MEMORANDUM

TO: Jean Fraser, Planner
FROM: David Senus, P.E. & Ashley Auger, E.I.T.
DATE: November 6, 2012
RE: 321 Commercial St. Mixed Use Development, Level III Final Site Plan/Subdivision Application

- Level III Site Plan/Subdivision Application and attachments dated October 22, 2012, prepared by Opechee Construction Corporation, on behalf of J.B. Brown & Sons.
- Engineering Plans, Sheets C01-C13, CMTC, S01 & CP01-CP04, dated October 22, 2012, prepared by Opechee Construction Corporation, on behalf of J.B. Brown & Sons.

SANITARY SEWER & STORM DRAIN DETAILS

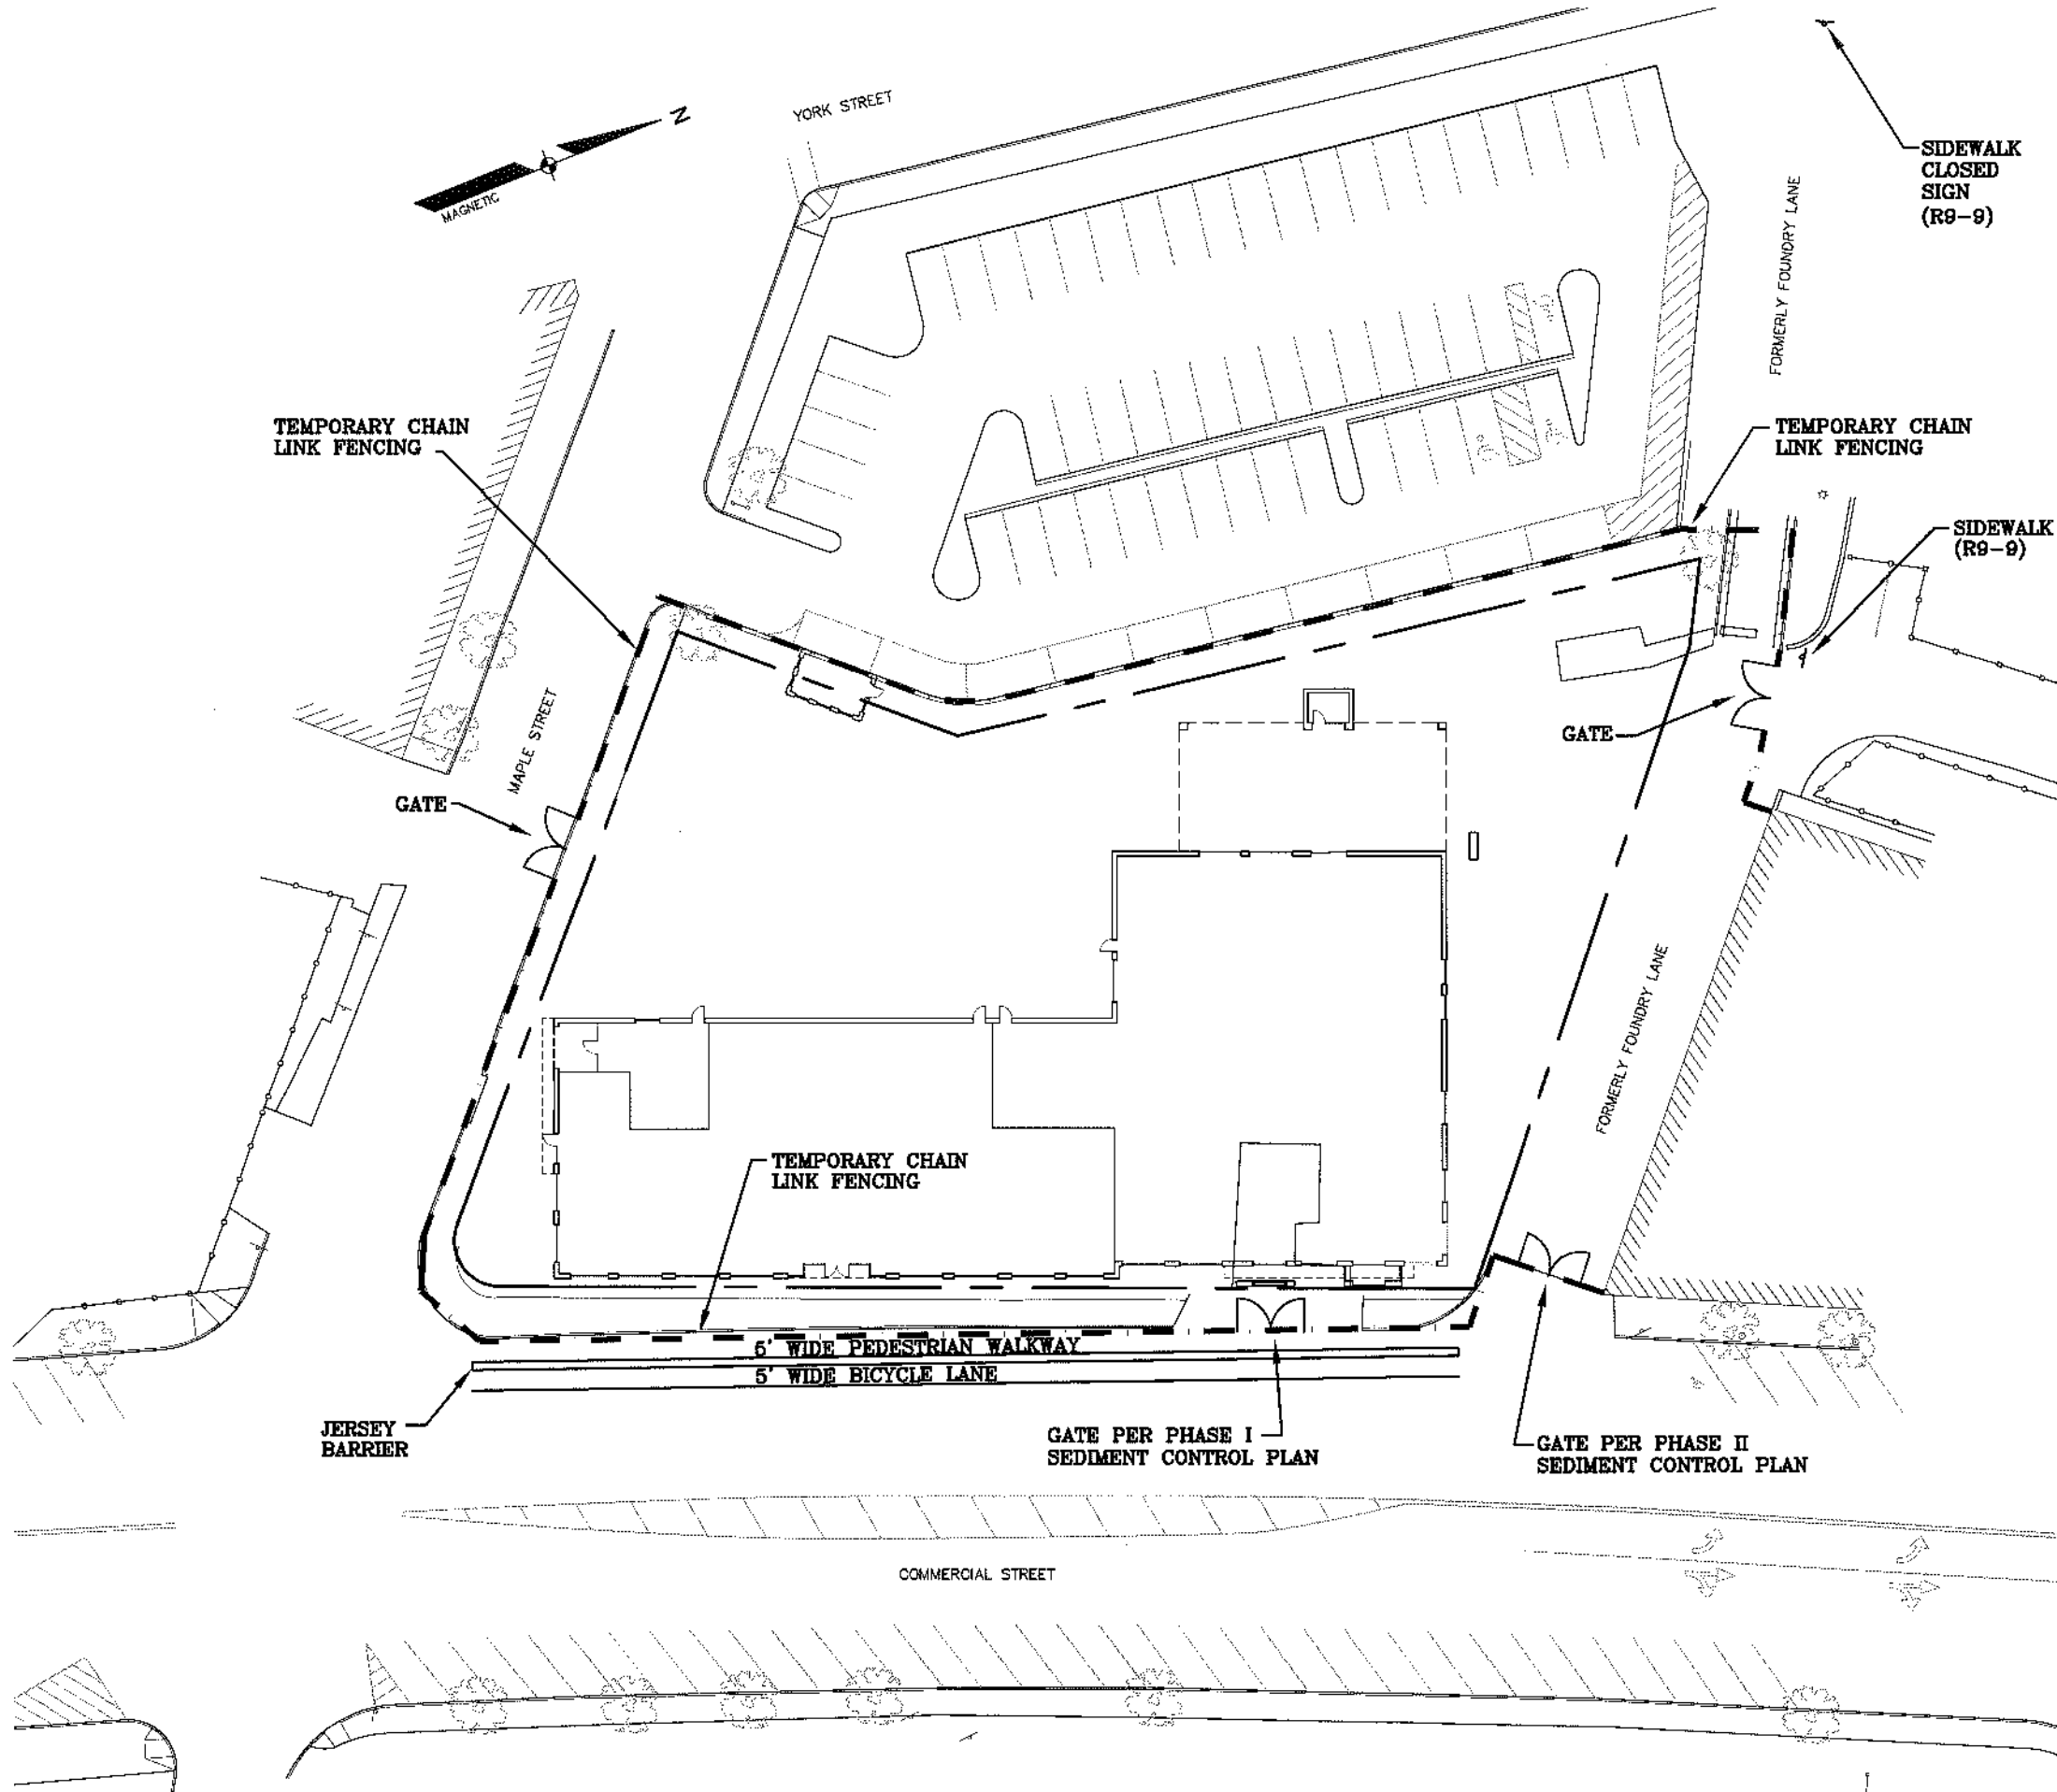
- 3) Please clarify the use of the "Catch Basin Inlet" detail versus the "Precast Catch Basin" detail (Sheet C11). Unless unique situations warrant, the City would require the "Precast Catch Basin" detail with 3' sump & outlet trap.
